IMMINGHAM EASTERN RO-RO TERMINAL

Document Information		
Project	Immingham Eastern Ro-Ro Terminal	
Document Title	Applicant's Response to Natural England's Deadline 6 Submissions	
Commissioned by	Associated British Ports	
Document ref	10.2.69	
APFP Reg 2009	Regulation 5(2)(q)	
Prepared by	IERRT Project Team	
Date	Version	Revision Details
11/12/2023	01 Deadline 7	Submitted at Deadline 7

**Figure 9.9**

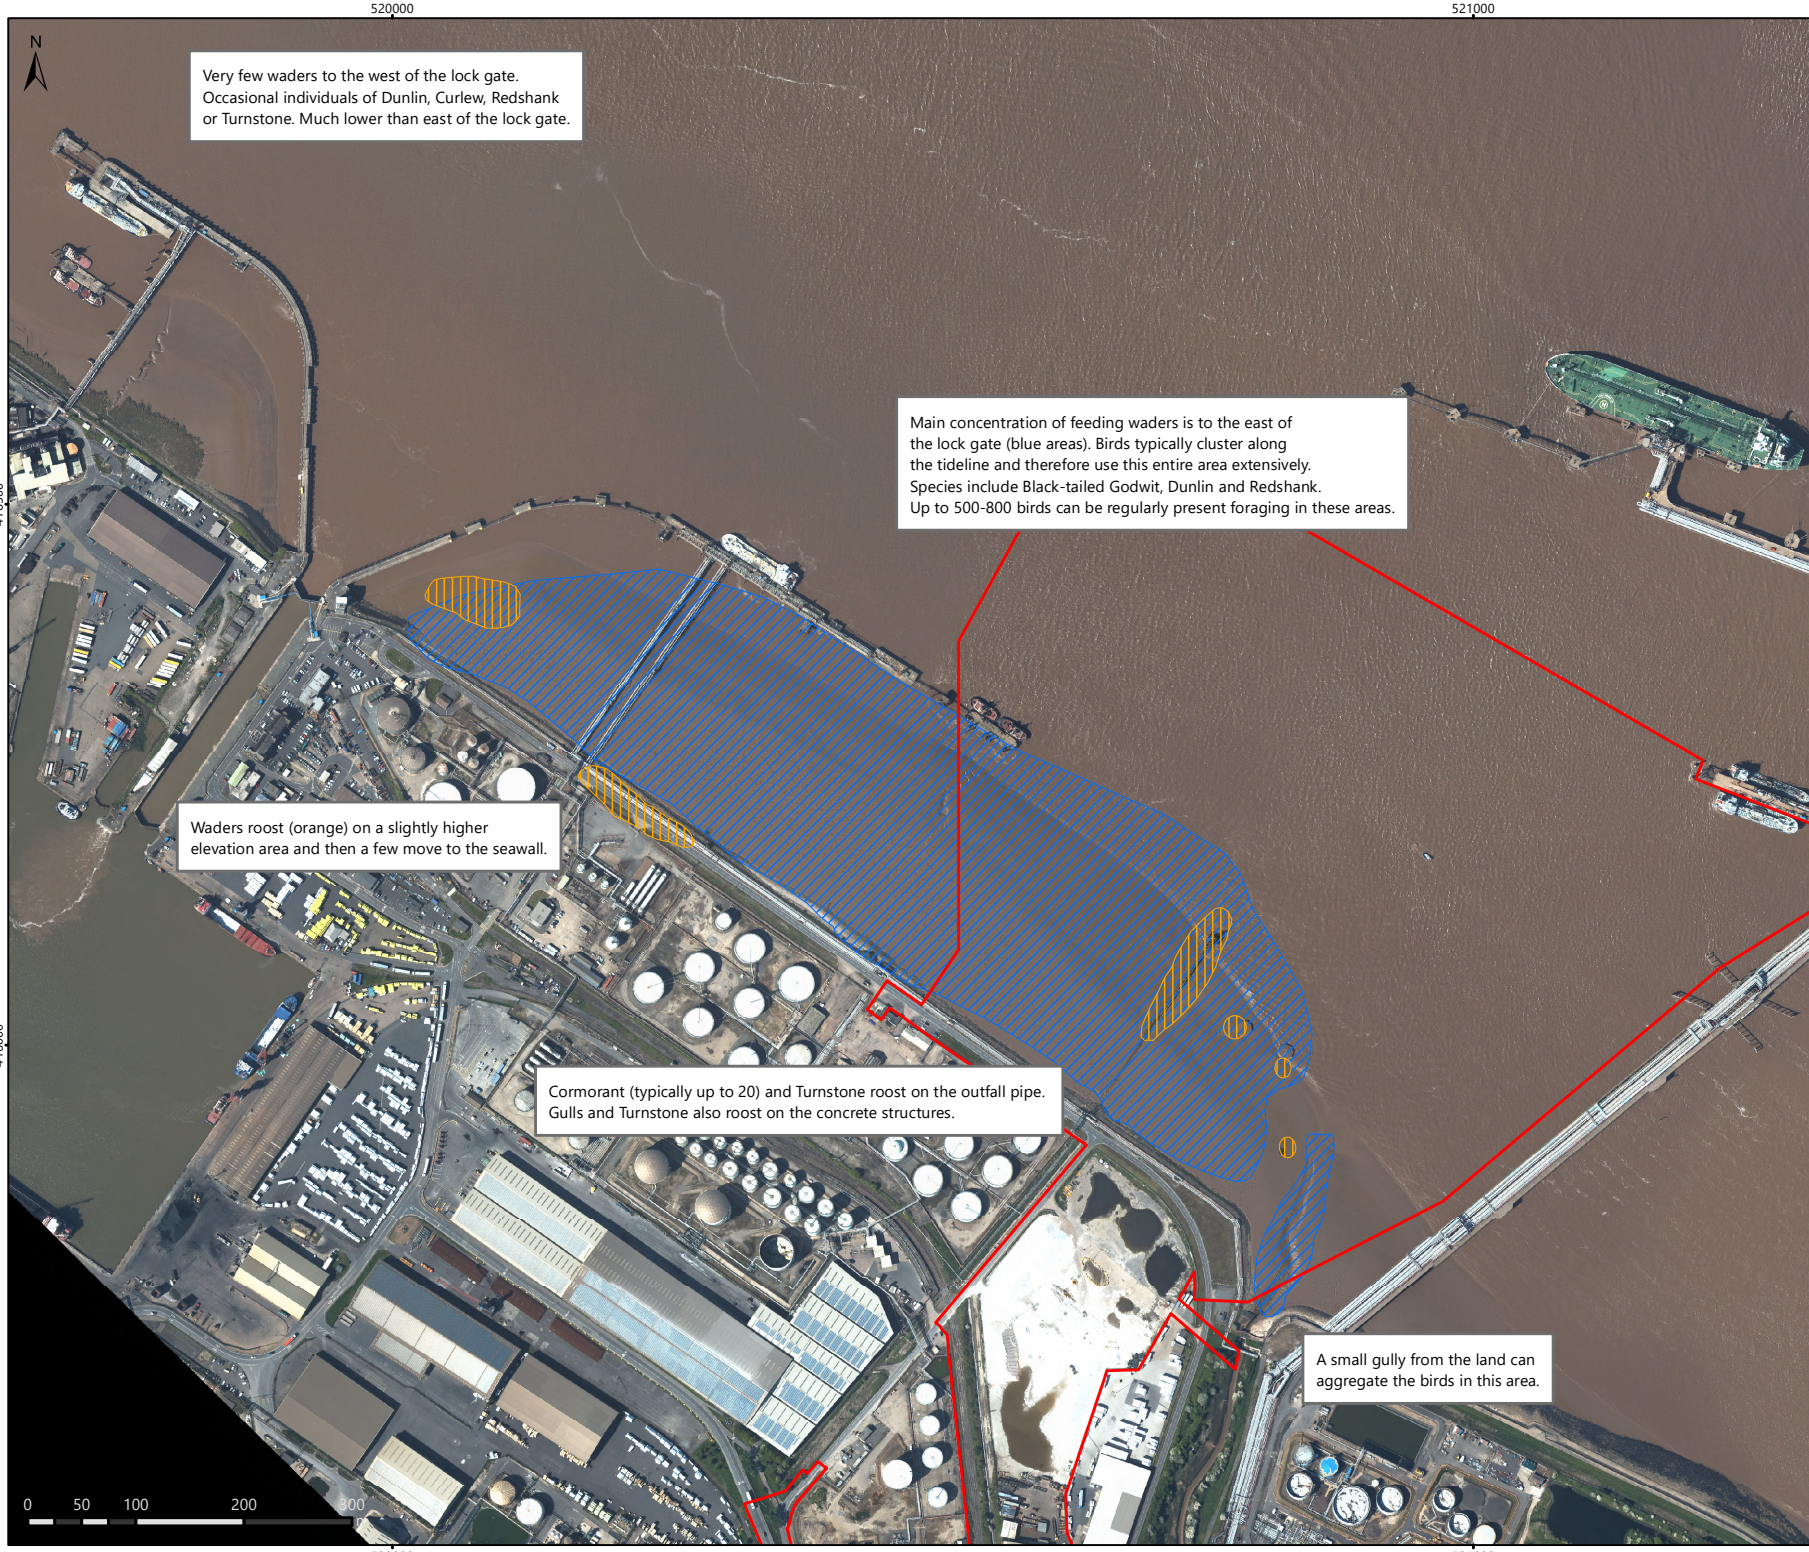
3.4 It is noted that Natural England welcomes the further information provided on this point including Figure 3 and Figure 4 of the HRA Report [REP5-020] showing the numbers and locations of foraging and roosting birds in the existing enclosed spaces within sector B. Natural England states that this provides some reassurance that birds may well continue to use the area around the new jetty even though it will be more enclosed and potentially has greater disturbance from people than before construction. Natural England recommend that post construction monitoring is conducted to identify whether similar numbers of birds continue to use Sector B once the jetty is in place, which will provide evidence for future port projects.

3.5 The Applicant agrees that post construction monitoring should be undertaken in Sector B to understand the abundance and distribution of birds once the IERRT infrastructure is in place. It is already proposed (as summarised in paragraph 4.10.56 of the HRA [REP5-020]) that coastal waterbird monitoring will be undertaken based on the same sectors and approach as the current Immingham Outer Harbour (IOH) surveys for the first two years of operation. The results of these surveys will be summarised as part of an annual report with the data used to help inform the evidence base with respect to both potential operational disturbance effects and as a result of the presence of infrastructure.

**CONSTRUCTION ACTIVITY ASSOCIATED WITH  
THE OUTER FINGER PIER AND POTENTIAL  
DISTURBANCE ZONE BUFFER**

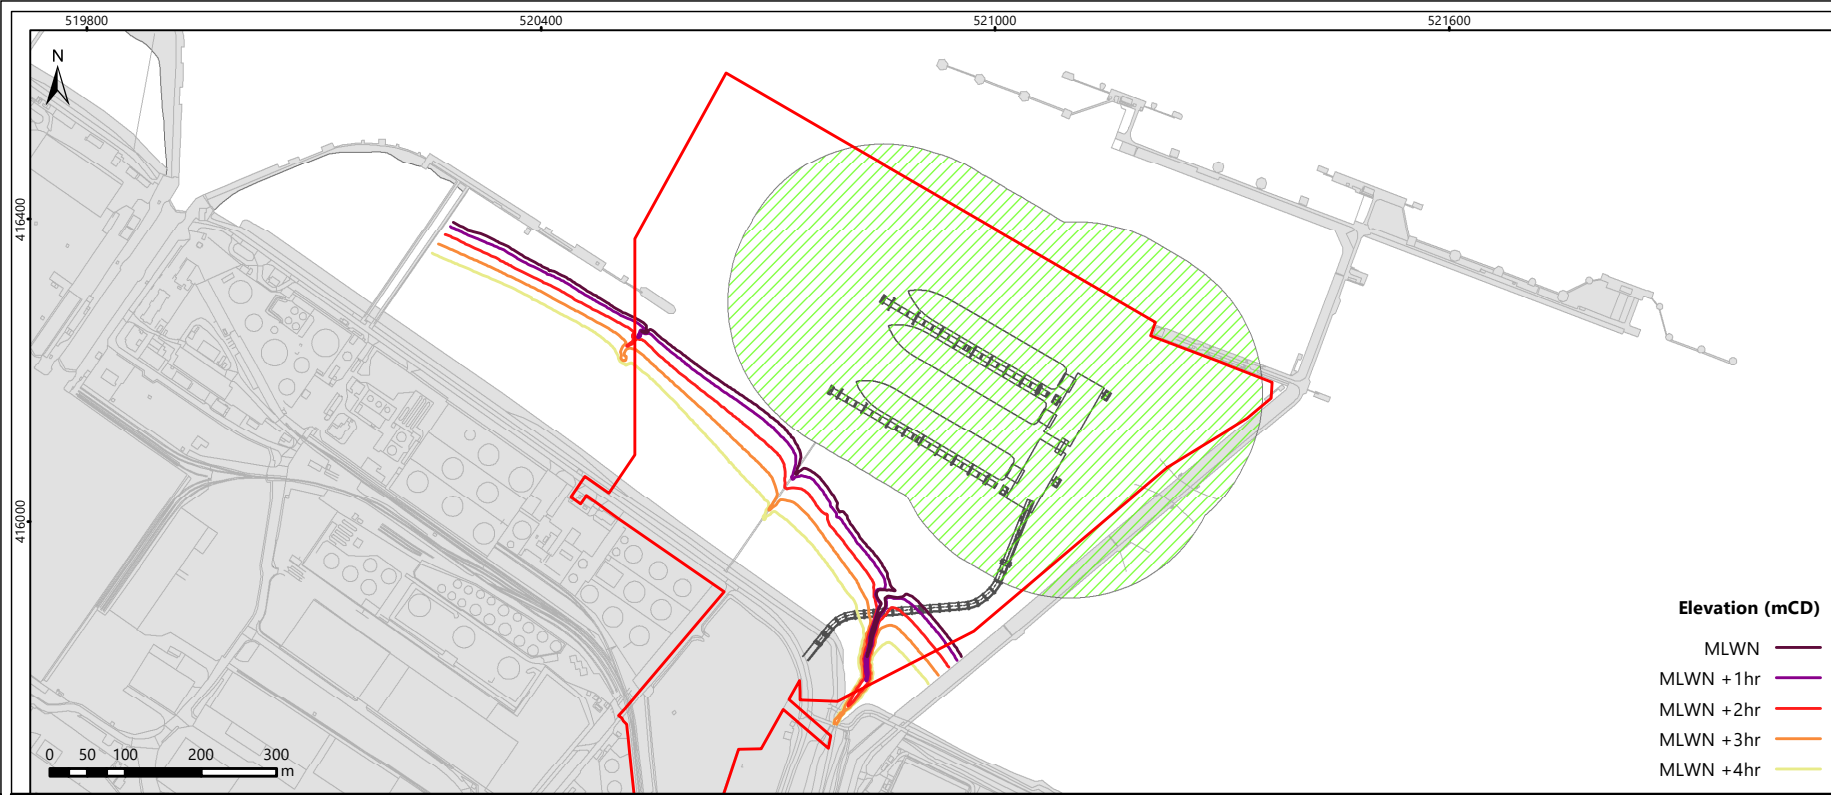
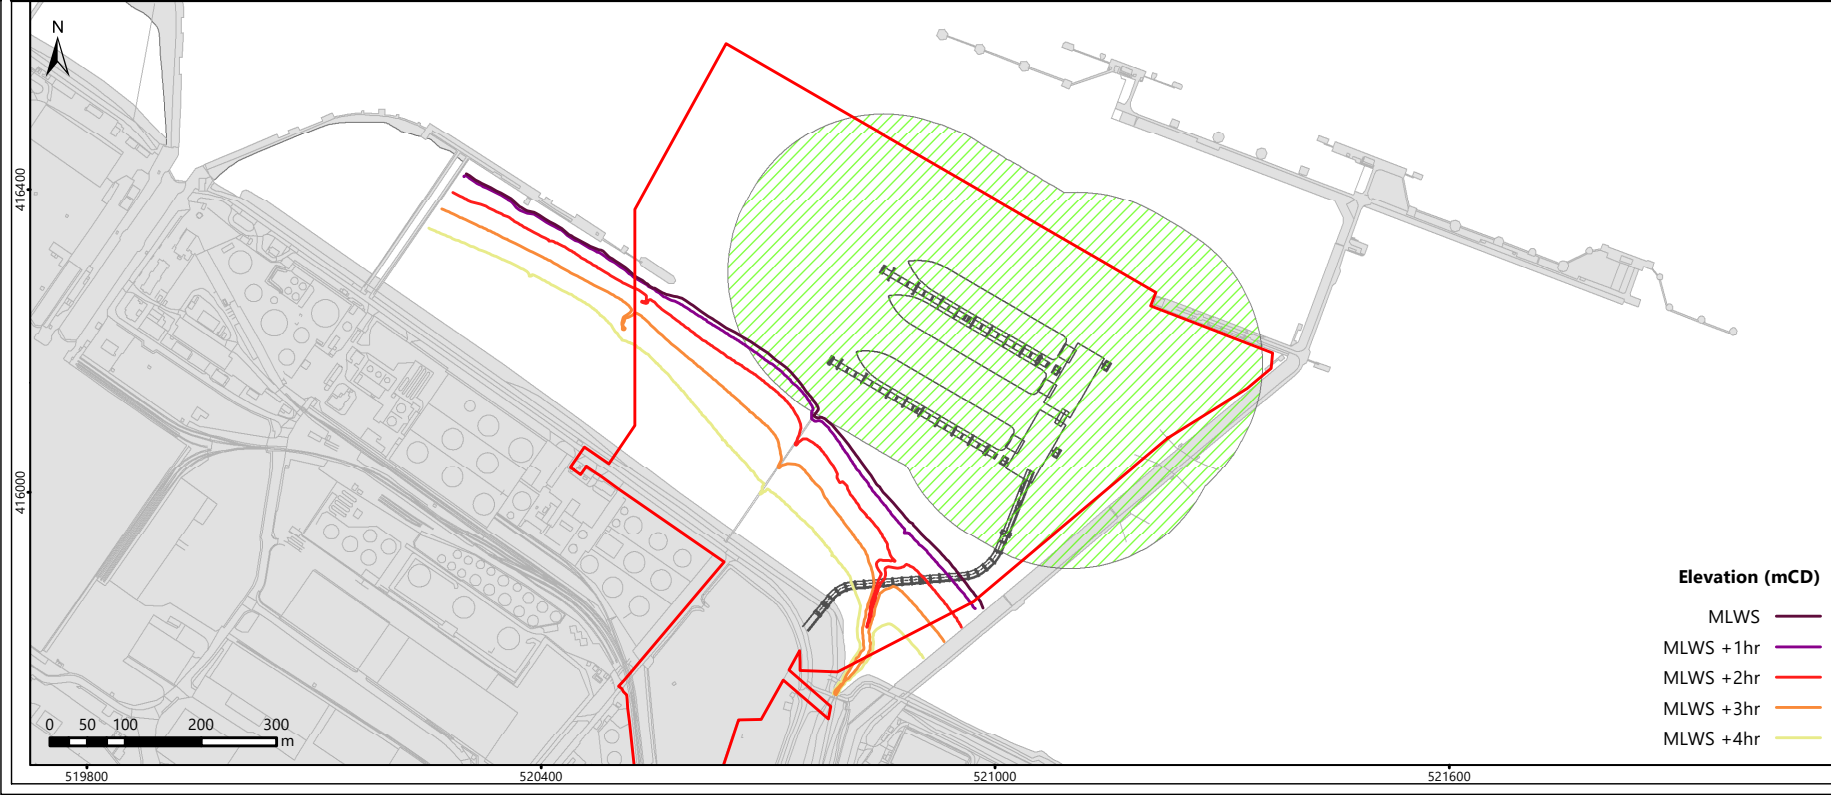
- 3.18 **At point 3) on mitigation Natural England state:** *‘No restrictions are being proposed for work on outer pier, but this would need to be reviewed should the disturbance distance be increased’.*

- 3.19 The Applicant would like to reiterate that a detailed assessment of the potential effects of construction of the outer pier is provided in paragraphs 4.10.28 and 4.10.29 of the HRA [REP5-020]. Based on that assessment, and the extensive evidence to support that assessment, mitigation was not considered to be required for the outer pier.

- 3.20 It is not clear to the Applicant what evidence there is to suggest mitigation is required for the outer finger pier with respect to bird disturbance during construction in a port environment, nor what evidence there is to justify the application of an increased disturbance distance.
